FG/41/20/PL

Subject: Ferringham House plans

Re: planning application FG/41/20 58 Ferringham Lane, Ferring

Southern Elevation As Proposed

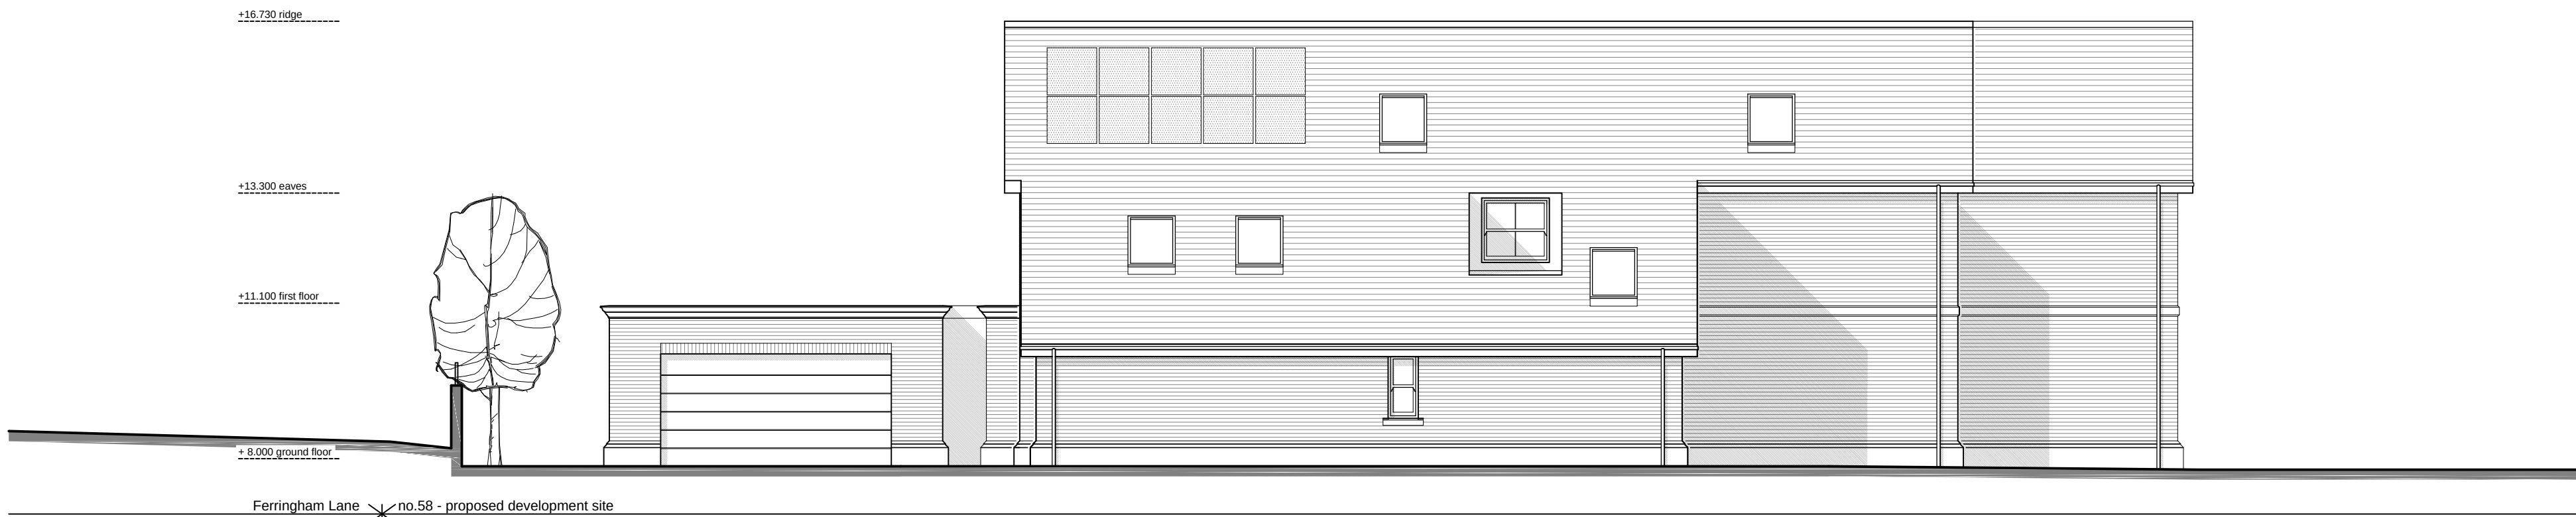
- 1) The rear of the proposed building, second floor, Southern elevation: the last window appears to overlook our rear garden and looks directly into our conservatory which forms an important part of our living area, used for dining and leisure. Obviously, we are not comfortable with the ability of anyone to observe our movements and activities, albeit from an upstairs window.
- 2) The Western boundary wall, as stated on page 7, is to be constructed in brick at a height of 1.2 metres. Due to the curve of the road to the right of the site facing North and bending right, this height would completely obstruct our view of oncoming traffic from the right when exiting our drive. This is a safety issue as, sadly, many vehicles use this road so would not allow a vehicle exiting our drive to edge forward to view the road. The shared fence between

Street Elevation As Proposed - 1:100 @ A1

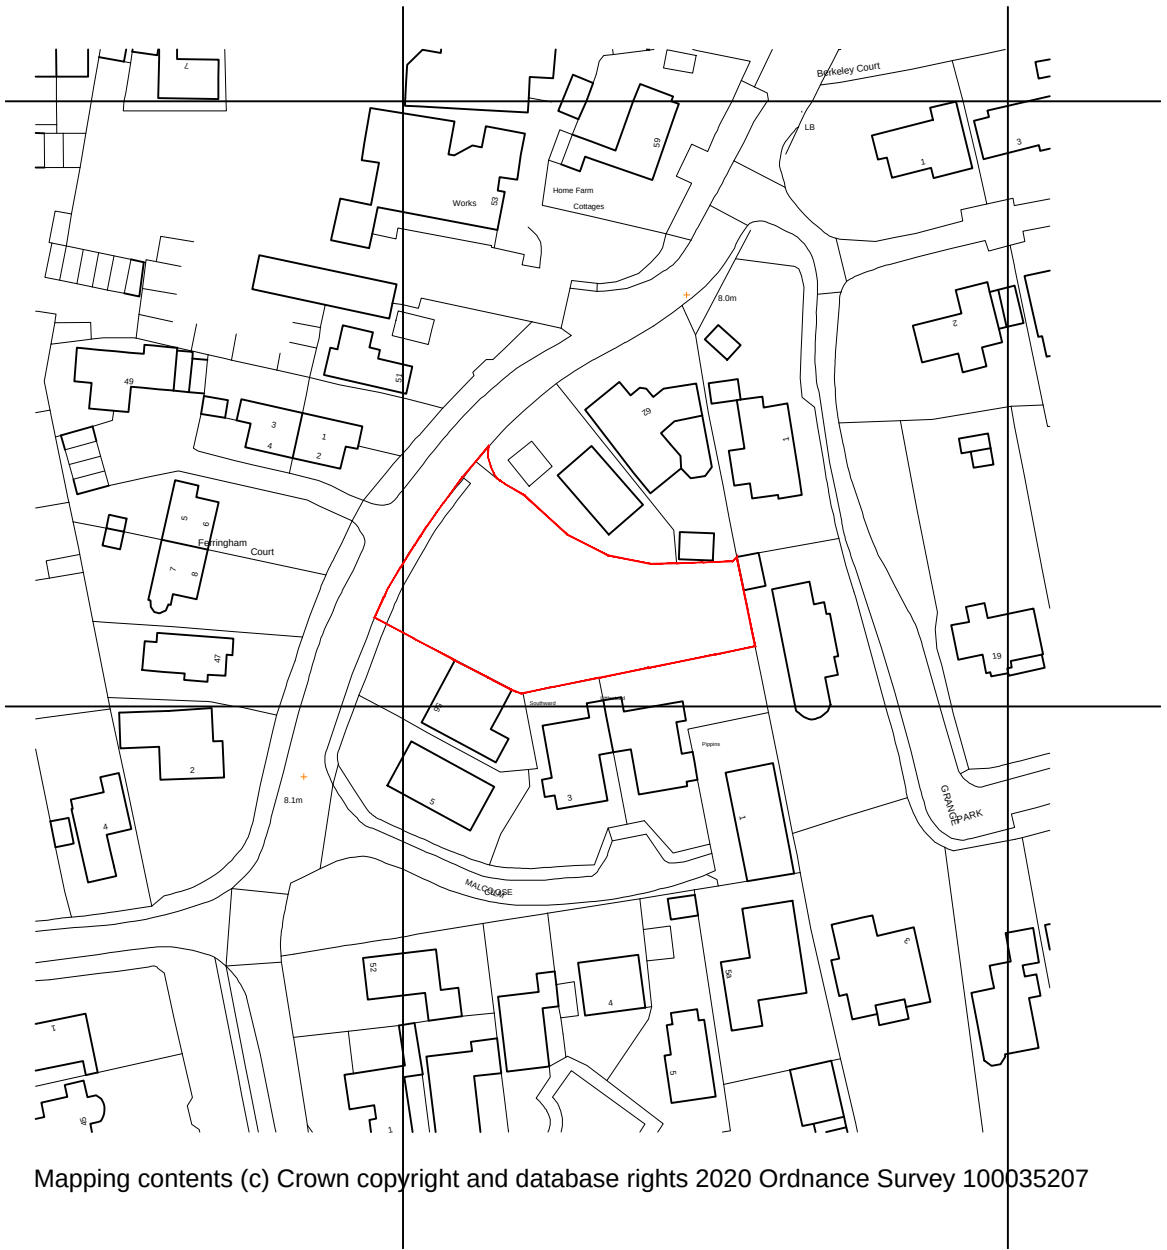
the properties and the hedge in the front corner, on 58's ground, have been kept to a specific height of 1 metre by agreement with the previous owners of the Retirement Home and latterly with Croudace, to allow clear vision.
